Medworth Energy from Waste Combined Heat and Power Facility

PINS ref. EN010110
Document Reference: Vol 6.4
Revision 1.0
June 2022

Appendix 12B Stakeholder engagement and consultation comments in relation to Hydrology

Figure 12.1
Proposed Development Location and Study Area

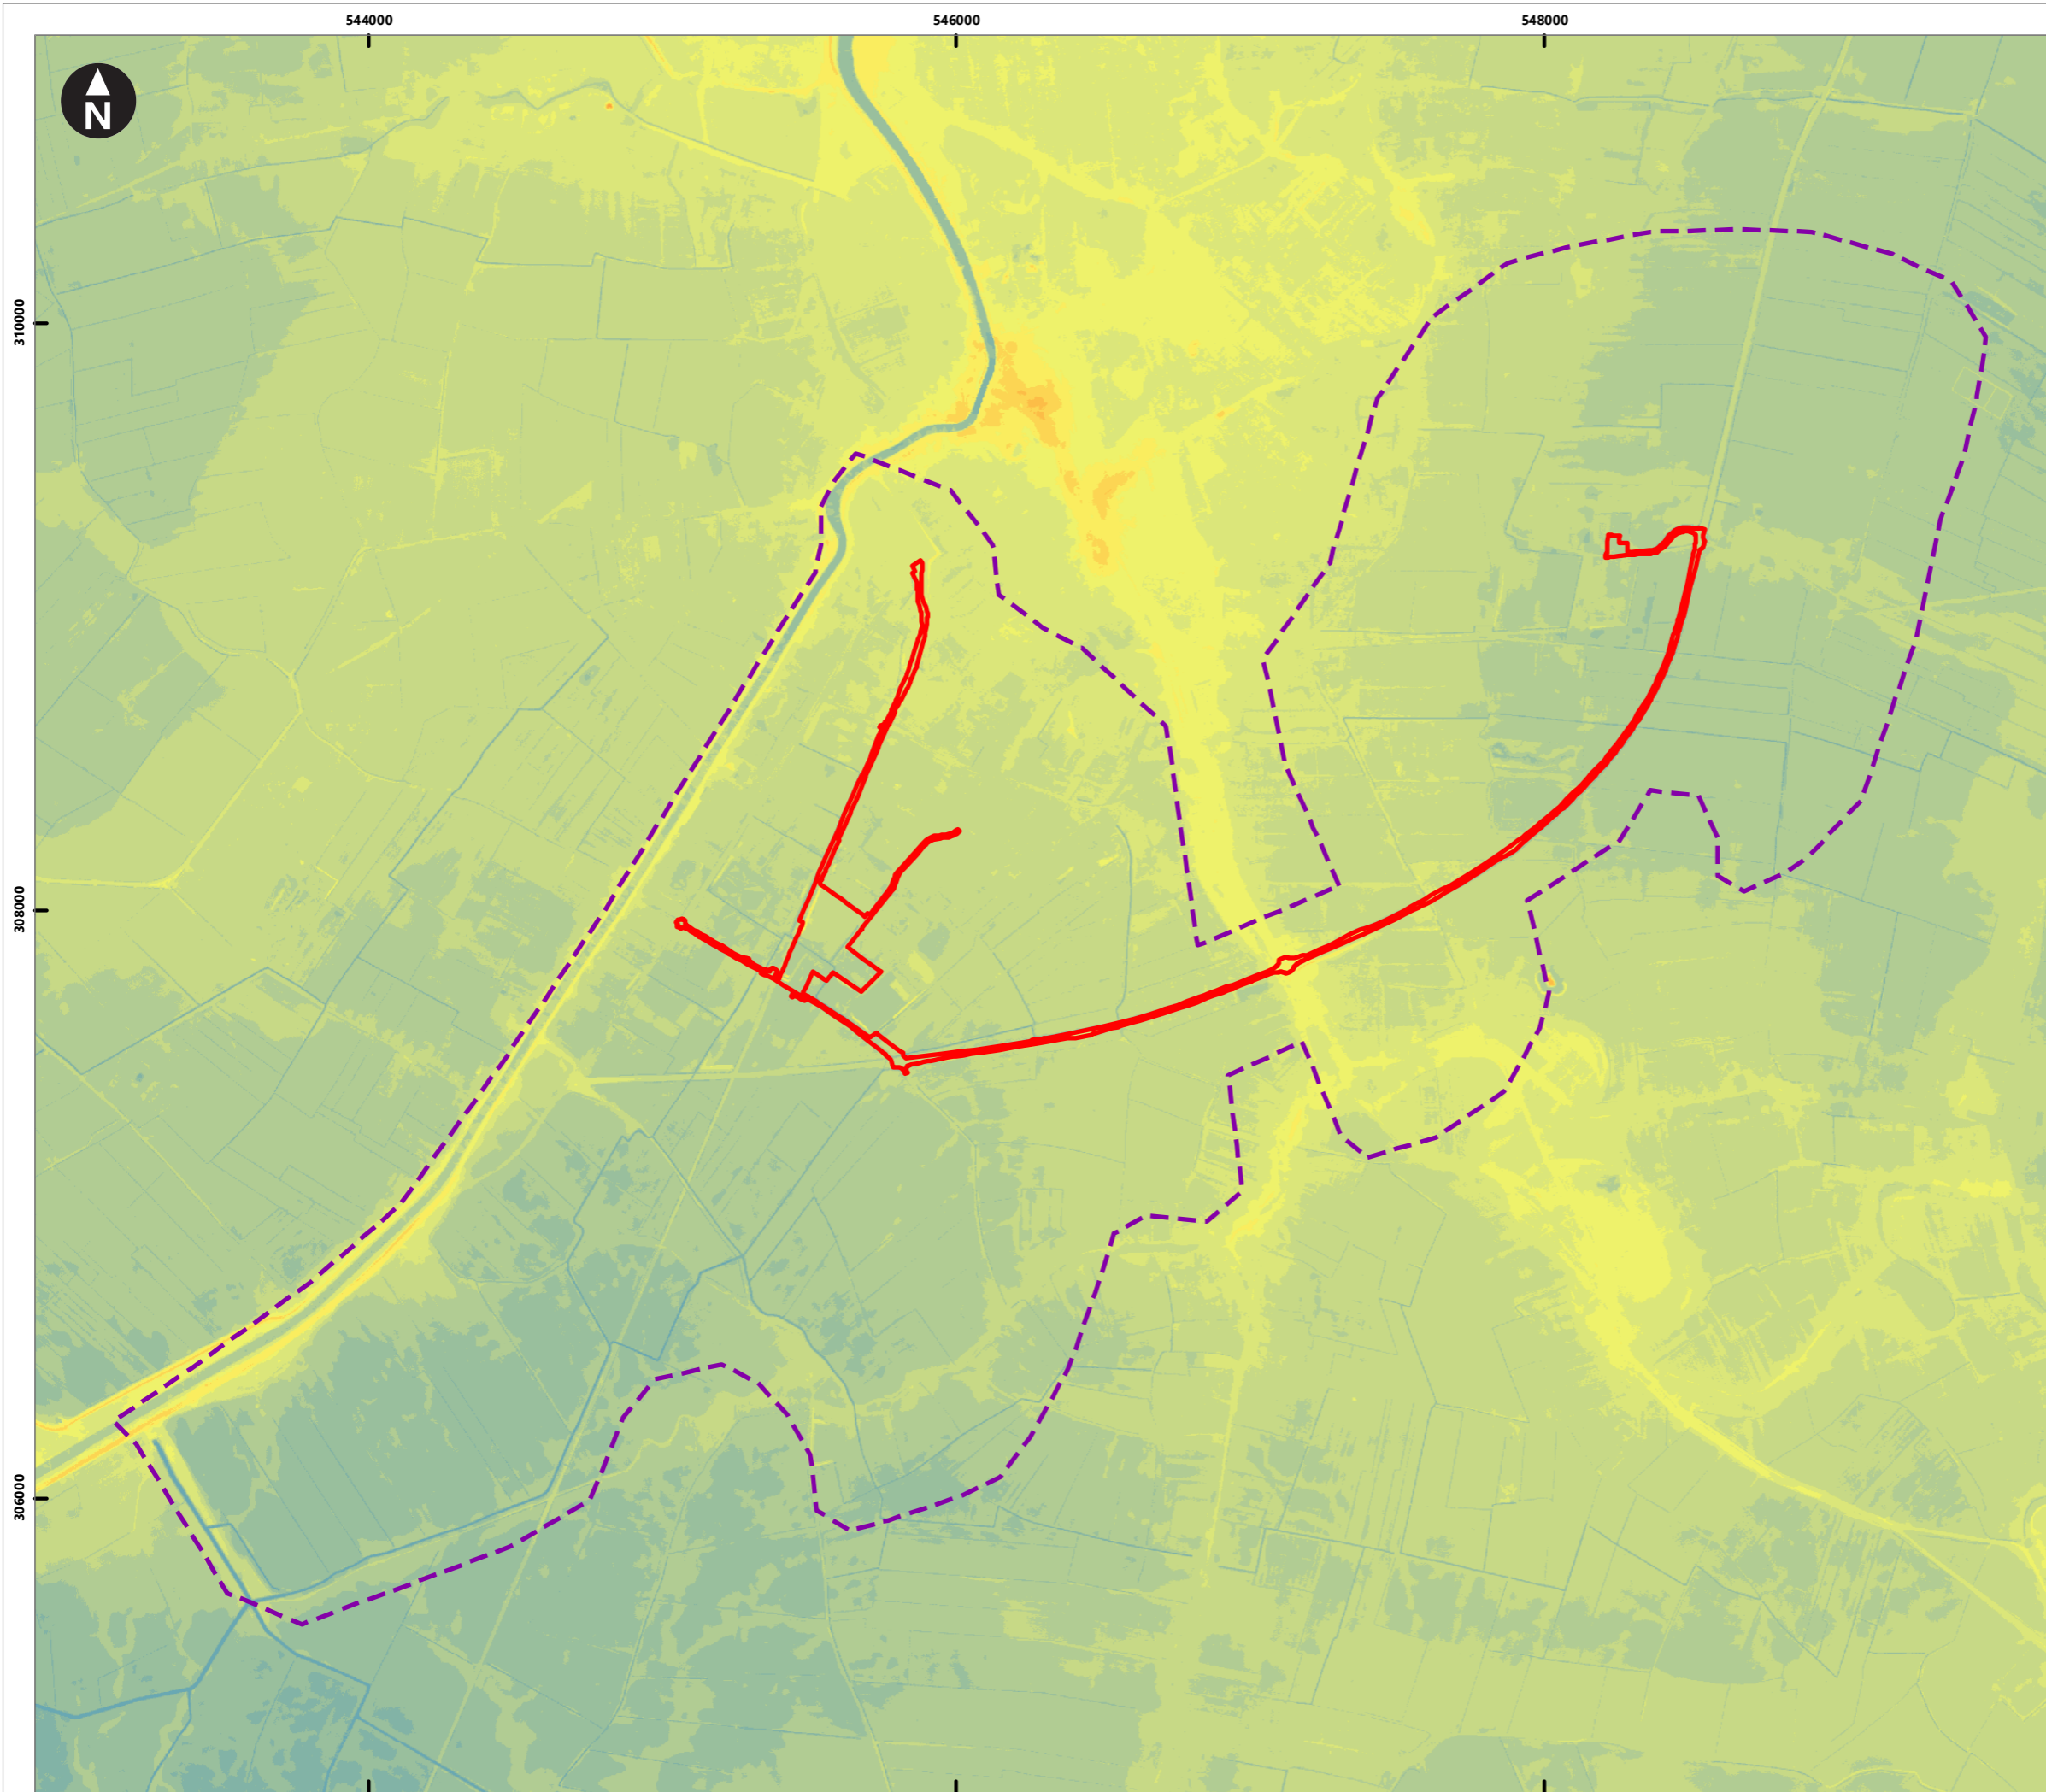
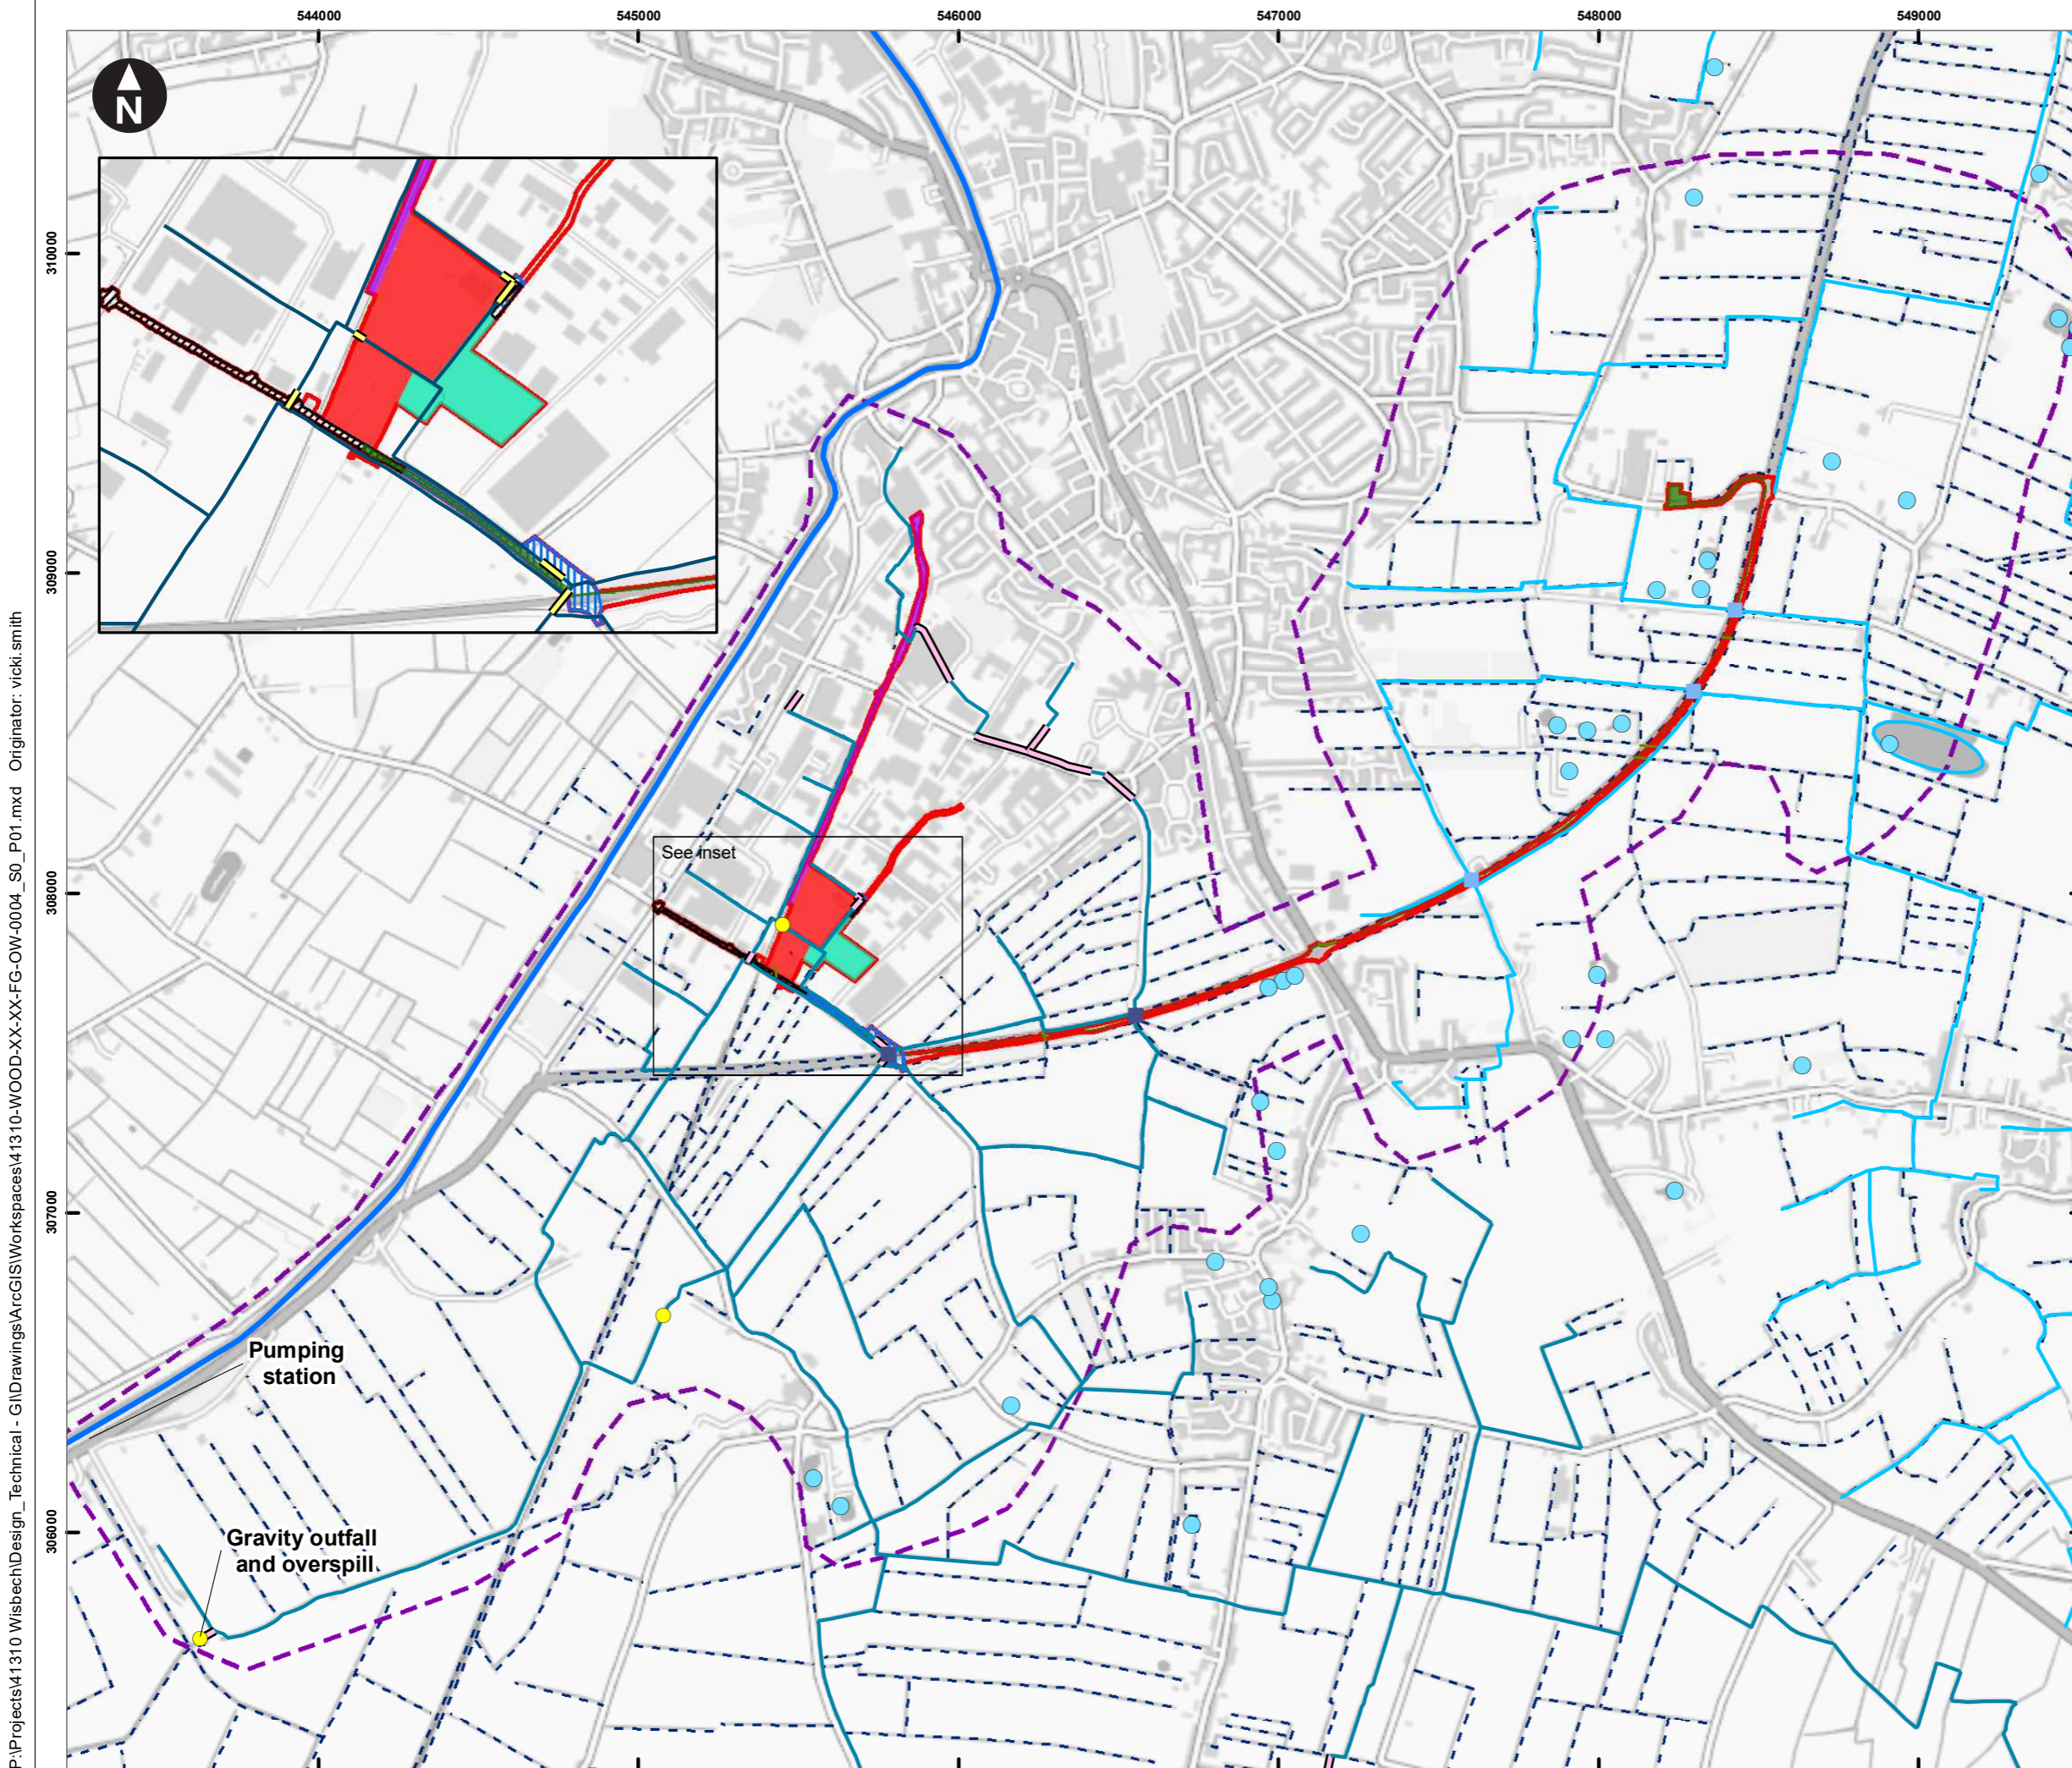
Consultee	Issue raised	Response
The Planning Inspectorate	Comment ID 4.7.2- Study Area Figure 10.3 of the Scoping Report depicts the water bodies located within 500m of the Proposed Development, yet the extent of the Study Area is described as being 1.5km from the Proposed Development. The Applicant should make effort to agree the Study Area with relevant consultation bodies. A plan should be provided which shows all of the hydrological features identified within the Study Area.	<p>The Study Area is defined in Section 12.4 and shown on Figure 12.3a.</p> <p>The hydrology Receptors within the Study Area are identified in Section 12.6 (Potential Receptors) and their location is shown on Figure 12.3a, Volume 6.4.</p>
The Planning Inspectorate	Comment ID 4.7.3- If the Proposed Development includes works that may affect the existing drainage regime, including ditches, these should be assessed in the ES where significant effects are likely to occur. The assessment should specifically address the works required for the Grid Connection and the use of HDD. Cross reference should be provided where there may be impacts on ecology or protected species.	<p>A small number of crossings of the Internal Drainage Board (IDB) system may be required for the underground cable element of the Grid Connection. The Hundred of Wisbech Internal Drainage Board (HWIDB) advised (consultation meeting on 25/03/20) that Horizontal Directional Drilling (HDD) is preferred as opposed to coffer dams and open trench construction.</p> <p>The potential impacts of watercourse crossings on the IDB drainage system and appropriate mitigation measures are assessed in detail in the Flood Risk Assessment (FRA) (Environmental Statement Appendix 12A, Volume 6.4) and cross referenced in Section 12.9 (Environmental assessment of Hydrology effects) of Environmental Statement Chapter 12: Hydrology. Potential impacts of watercourse crossings on the ecology or protected species are assessed in detail in Chapter 11: Biodiversity and is cross referenced in Section 12.9 (Environmental assessment of Hydrology effects) of Environmental Statement Chapter 12: Hydrology, Volume 6.2 where required.</p>
